**West Yorkshire Police
Kirklees District**

Ref: 2023/91116

Date: 18th May 2023

Site Location: Land off Primrose Lane, Hightown, Liversedge, WF15
Application Type: 67 x Residential Dwellings

PRIMROSE LANE
 PROPOSED SITE LAYOUT

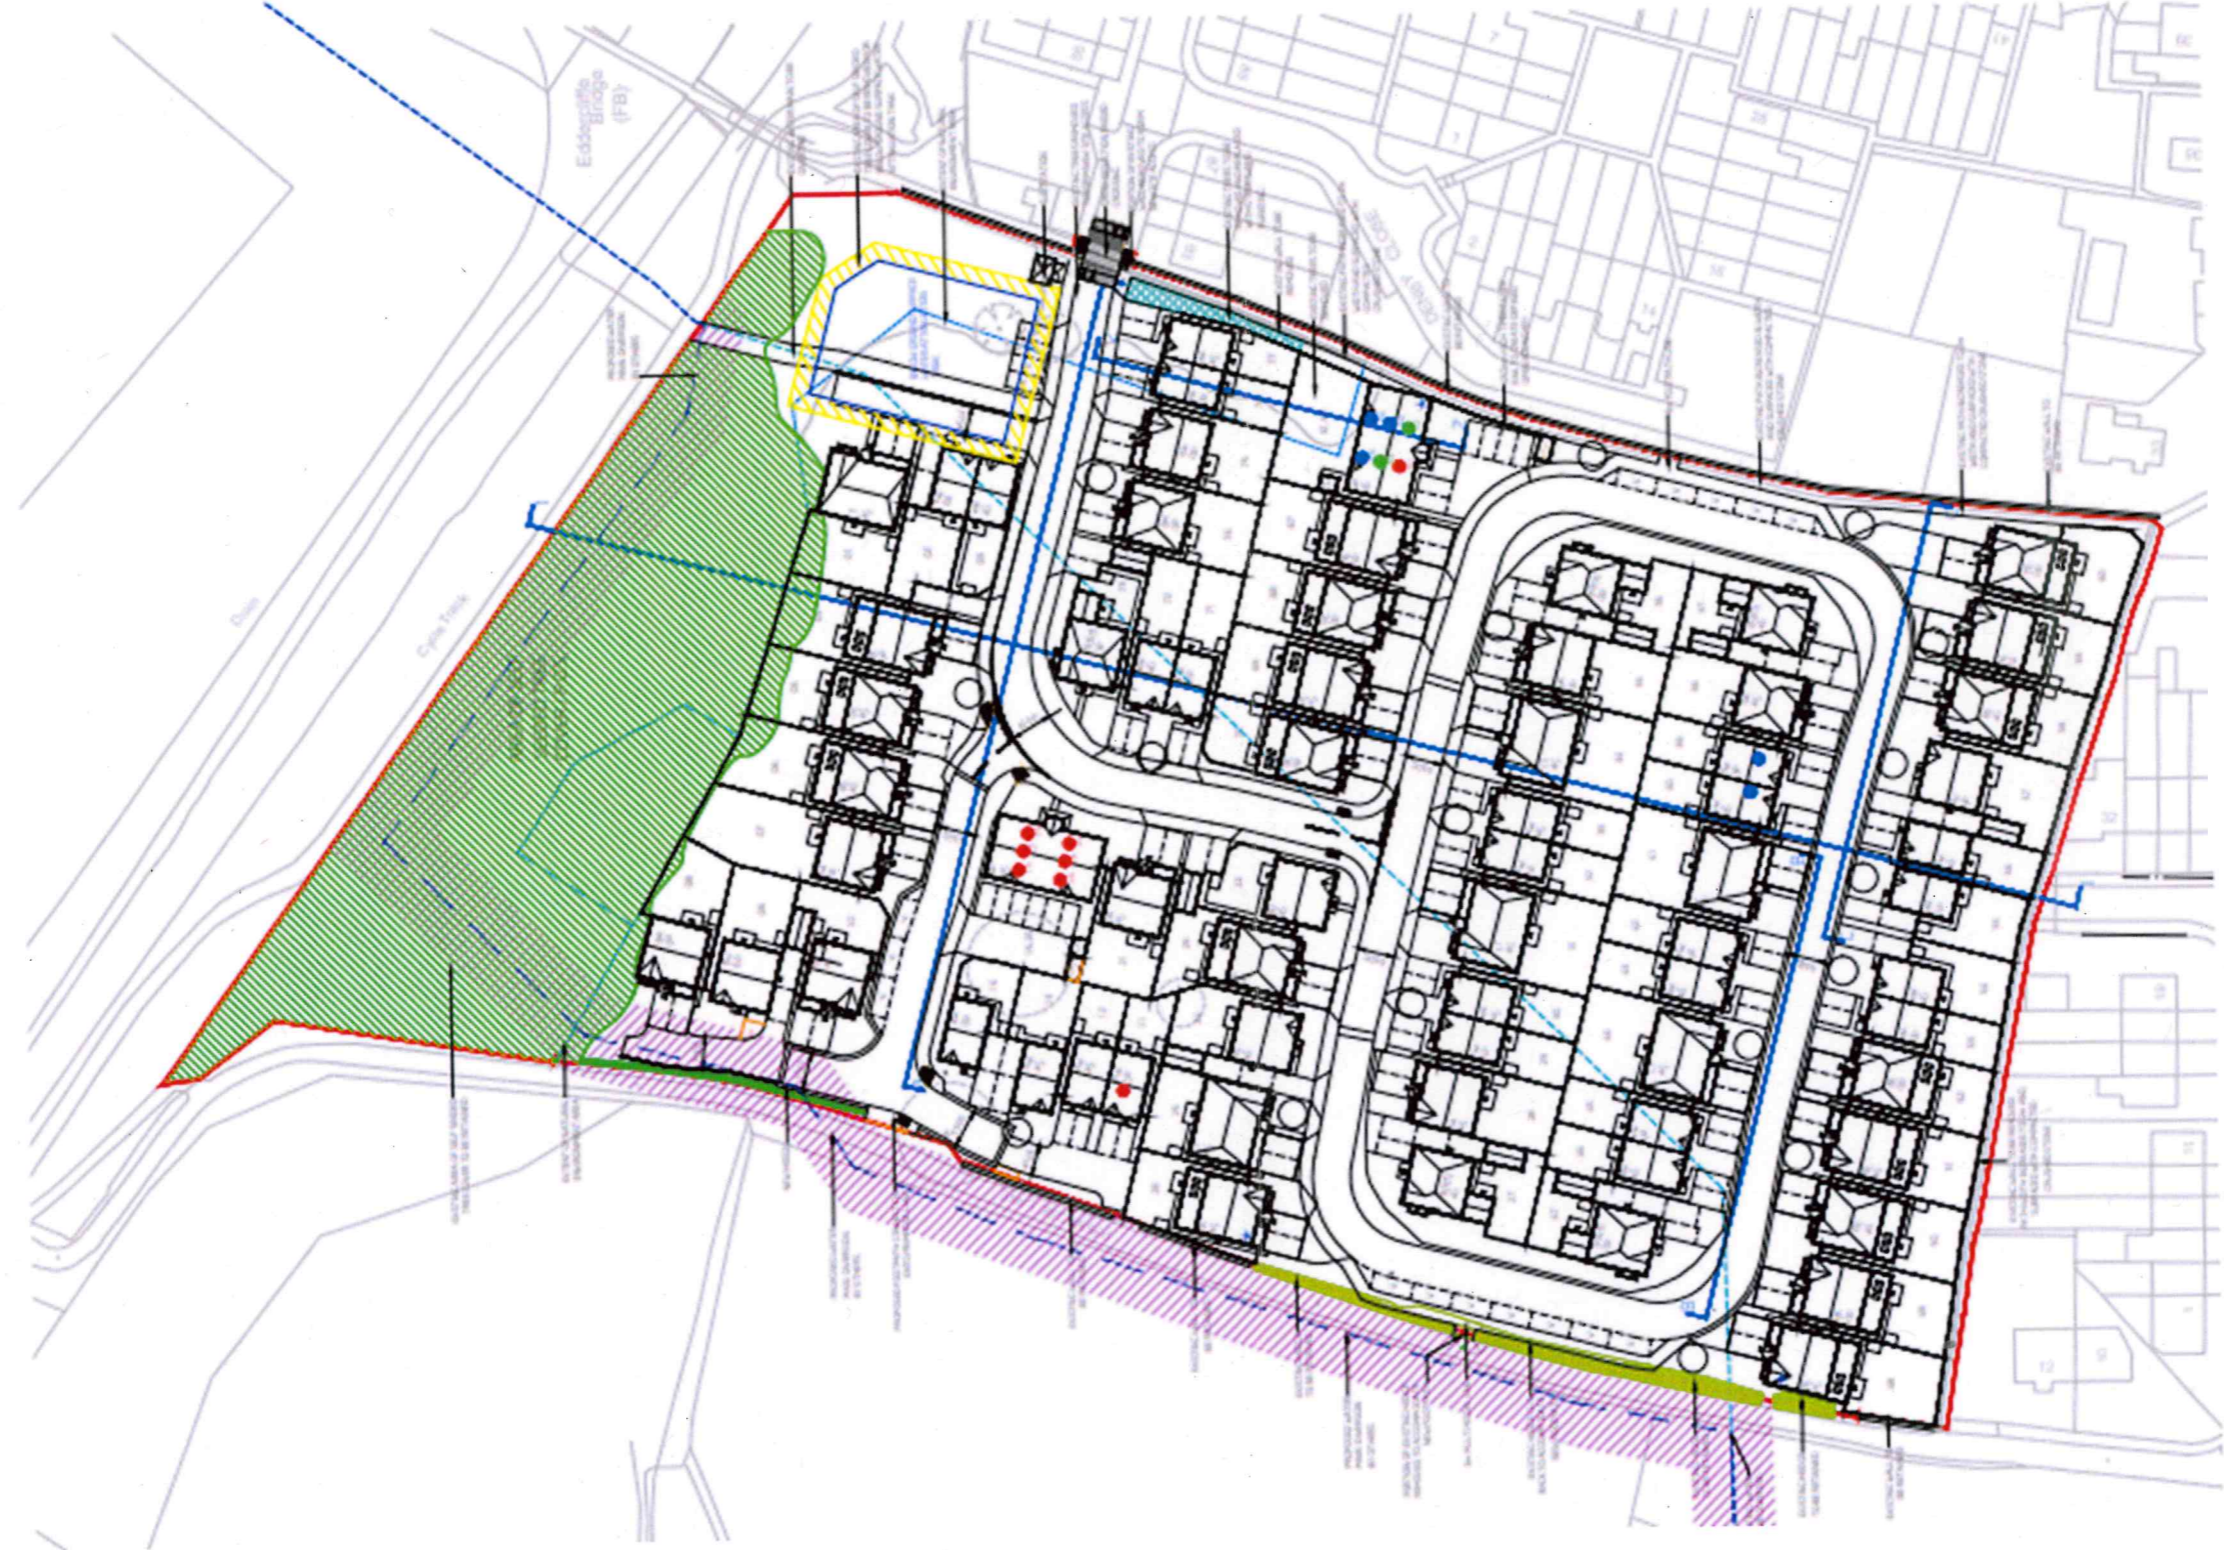
1. **Boundary Treatments** – Plots 1 and 9 are concerning as there is no defensible space to the north elevation. The rear gardens are protected by the proposed fencing, but there is no defined boundary to the land around the properties. Could this be addressed please.

There is a question mark over the shown blank land behind plots 16 to 25. I would like to suggest that this perimeter is defended by hostile planting. There is a concern that if this land is unused, it is likely to become a play space which may attract anti-social behaviour from young residents.

It is recommended that the shown timber knee rail to the east of plot 55 be supplemented with defensible planting to separate it from the PROW. This planting is advised to extend from the shown plot boundary treatment up to the footpath link. The planting will require a maintenance programme to keep it to a maximum of 1m in height to ensure good natural surveillance across the site.

2. **Vehicle Parking** – Plot 9 is showing the parking spaces away from the property. It is recommended that these spaces be brought into the front curtilage to improve the security of the vehicles. The shown spaces are adjacent to Primrose Lane and could be easily accessed by offenders.
3. **Lighting Plan** – Full details of the site lighting scheme. This must include any un-adopted roads and Private Drives. Bollard lighting is **NOT** recommended for streets, roads and parking areas, as they do not enable facial recognition due to the light spill being at low level.
